RE: Intake Screening - 2112-184– 9017 SE 60TH ST, MERCER ISLAND
Blueline Job No. 21-377

This letter is in response to your review of the 9017 SE 60th St project. The plans have been revised per the comments in your letter dated 1/4/2022. Below is a list of each comment with our responses in bold.

6/1/22  
 JOB NUMBER:  
**21-377**  
 SHEET NAME:  
**TP-01**  
 SHT **2** OF **5**

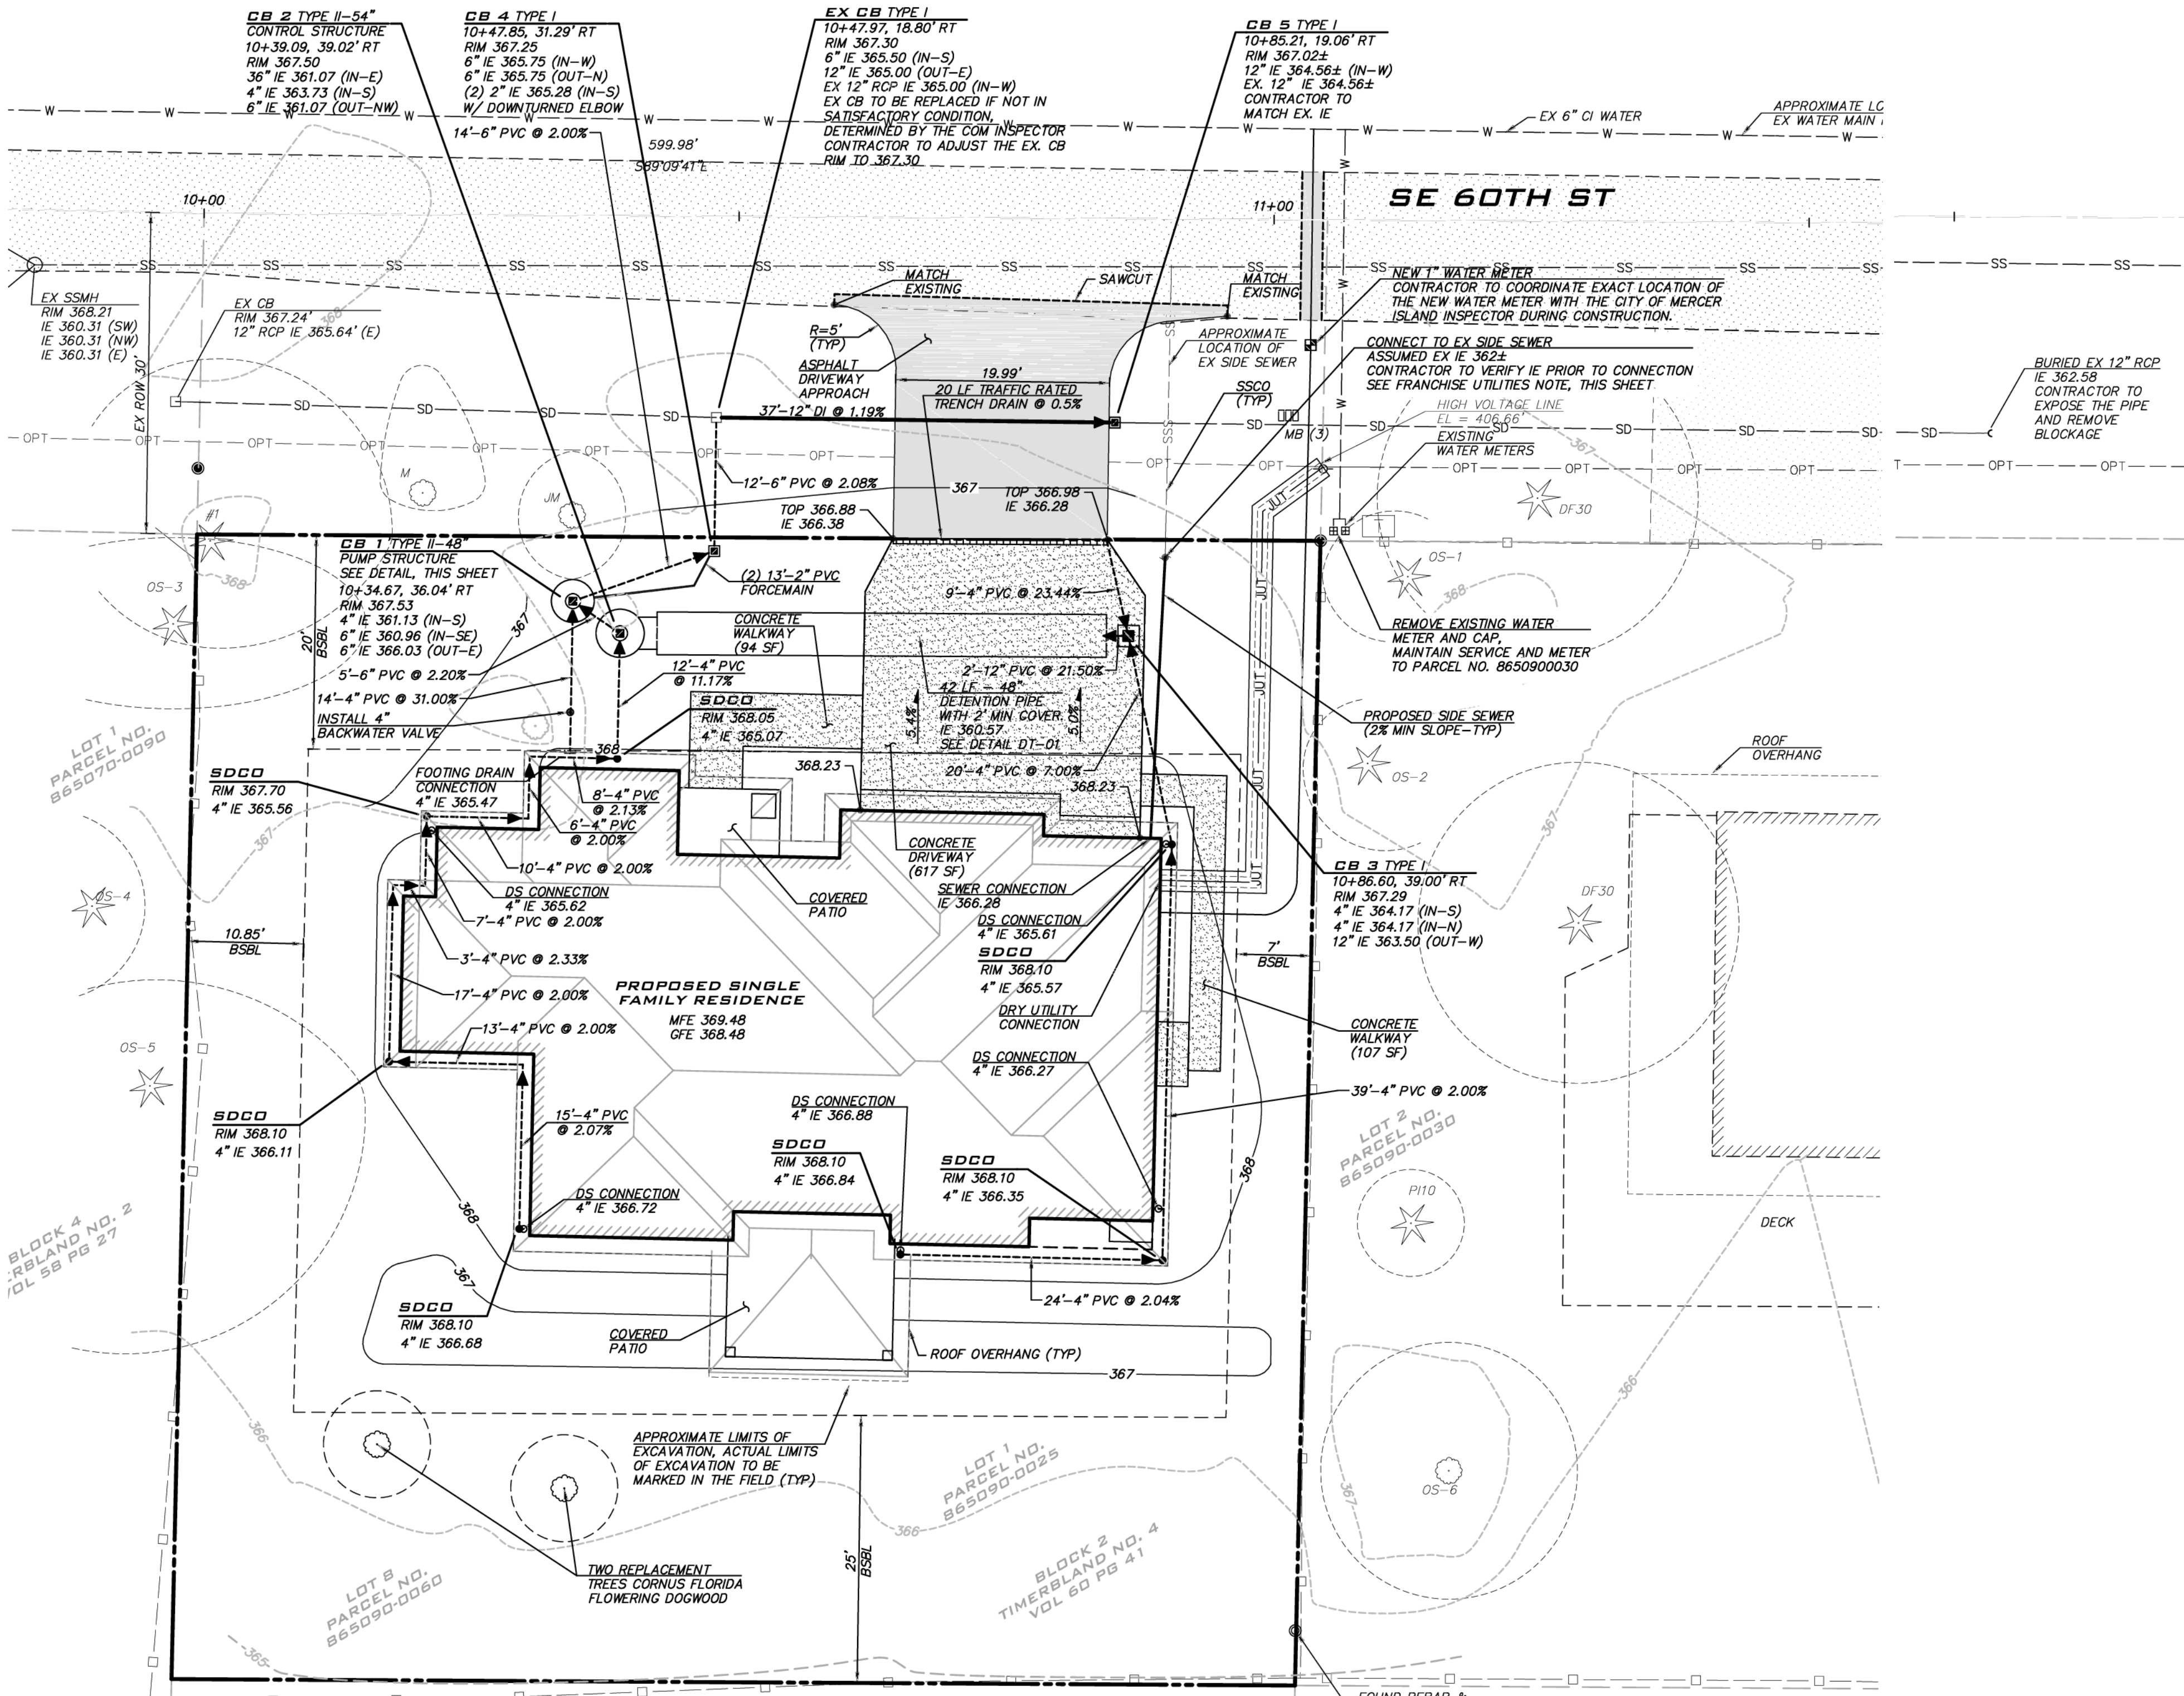
1. The drainage design for the roof downspouts will have potential erosion or flooding to the downstream property due to the relatively small lot and non-infiltrated soil on site.

Storm design has revised to provide an on-site detention tank per the City of Mercer Island On-site Detention Design Requirements Handout. Due to the limited depth of the existing storm system at the property frontage and minimal slope downstream, runoff from the detention tank will be pumped to the existing storm system in the right-of-way.
